**KIRKLEES METROPOLITAN COUNCIL
INVESTMENT & REGENERATION SERVICE**

DELEGATED DECISION TO DETERMINE PLANNING APPLICATIONS

Reference No:	2023/62/91137/E
Site Address:	214, Northstead, Ravensthorpe, Dewsbury, WF13 3EA
Description:	Erection of single storey front and side extensions
Recommending Officer:	Jennifer Booth

DECISION - REFUSED

PROPOSED GROUND FLOOR

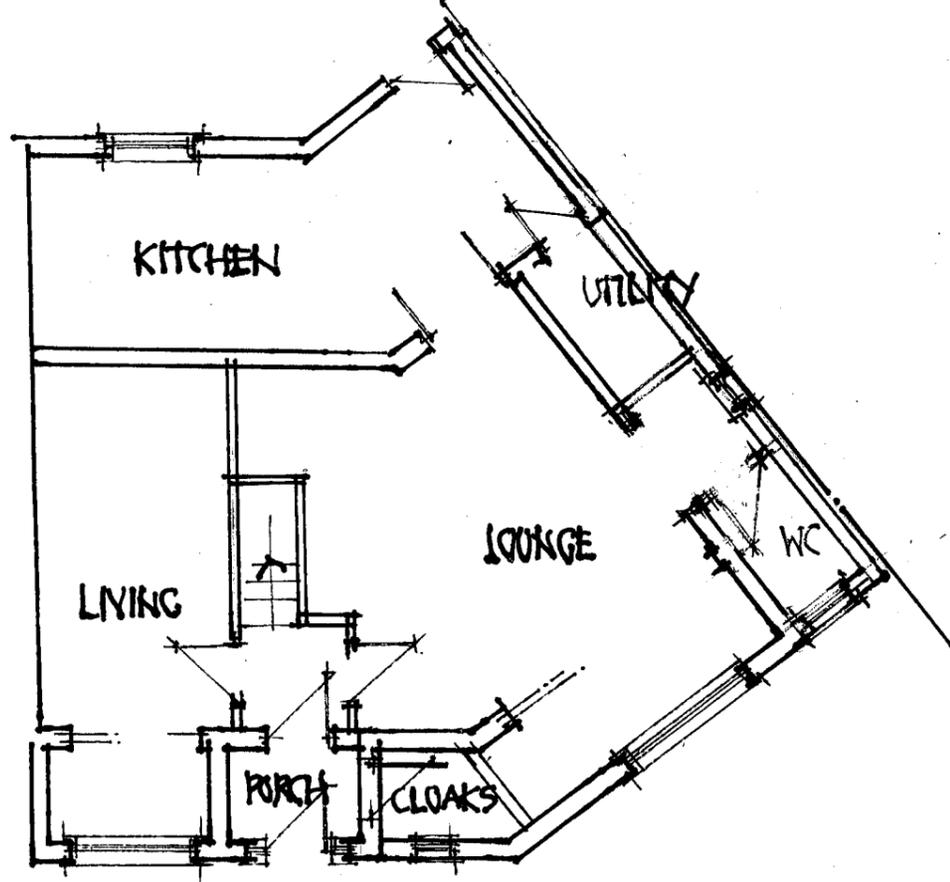
The property has a live permission for a front extension on the main front elevation of the dwelling. The current proposals seek to extend the front extension in front of the angled section of the front elevation utilising matching materials. The full width nature of the extension proposed would introduce an incongruous feature in the street scene, when considering the character and appearance of those dwellings to the west, furthermore the entirety of the front of the property would be obscured by the development. Therefore, the proposals fail to comply with Policy LP24 of the KLP, KDP1 & KDP2 of the House Extension SPD and advice within chapter 12 of the NPPF.

Having taken the above into account, the proposed front extension would form an incongruous feature in terms of the host dwelling and the wider street scene, thereby failing to comply with Policy LP24 of the Kirklees Local Plan, KDP 1 & 2 of the House Extension & Alterations SPD and the aims of chapter 12 of the National Planning Policy Framework.

The proposed front extension, by reason of its design, width and projection, would not form a subservient addition to the property and would result in the formation of an incongruous feature harmful to the character of the host property and the wider area. To permit the extension would be contrary to Policy LP24 of the Kirklees Local Plan, KDP1 and KDP2 of the House Extension SPD and advice within Chapter 12 of the National Planning Policy Framework.

ELEVATIONS

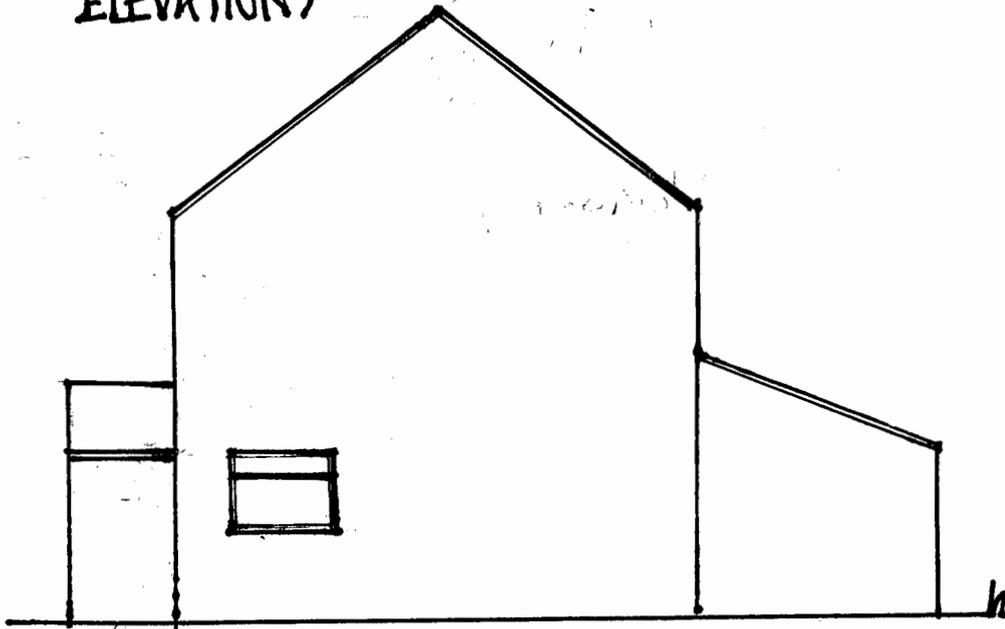
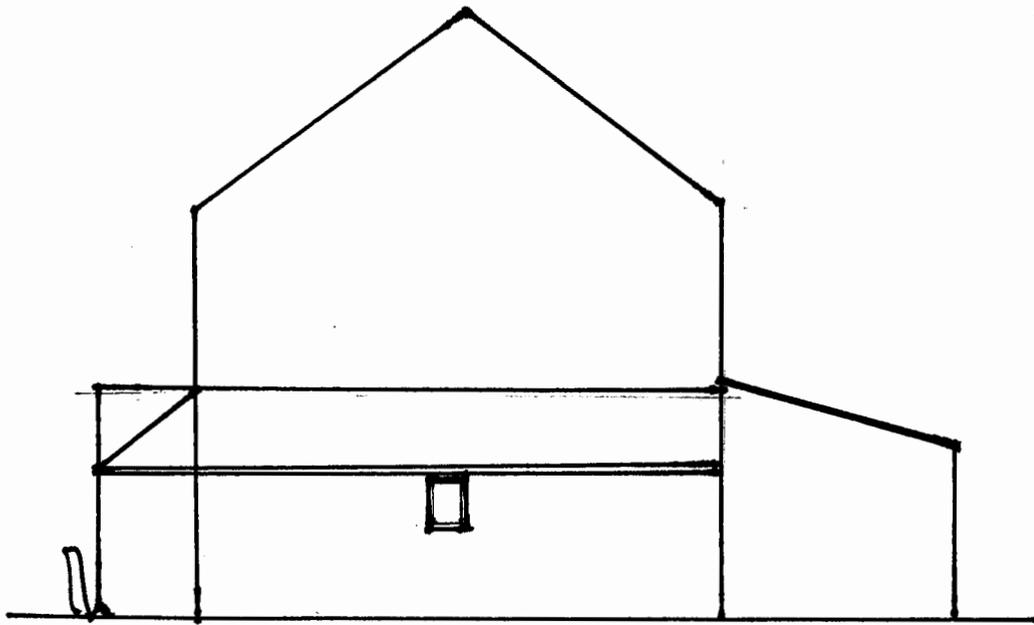
The side extension would infill the area to the side of the dwelling up to the shared boundary with the adjoining property. This element of the scheme would be single storey and relatively small in scale and would utilise materials to match the main house. On balance, the side extension can be considered to be acceptable in terms of visual amenity.
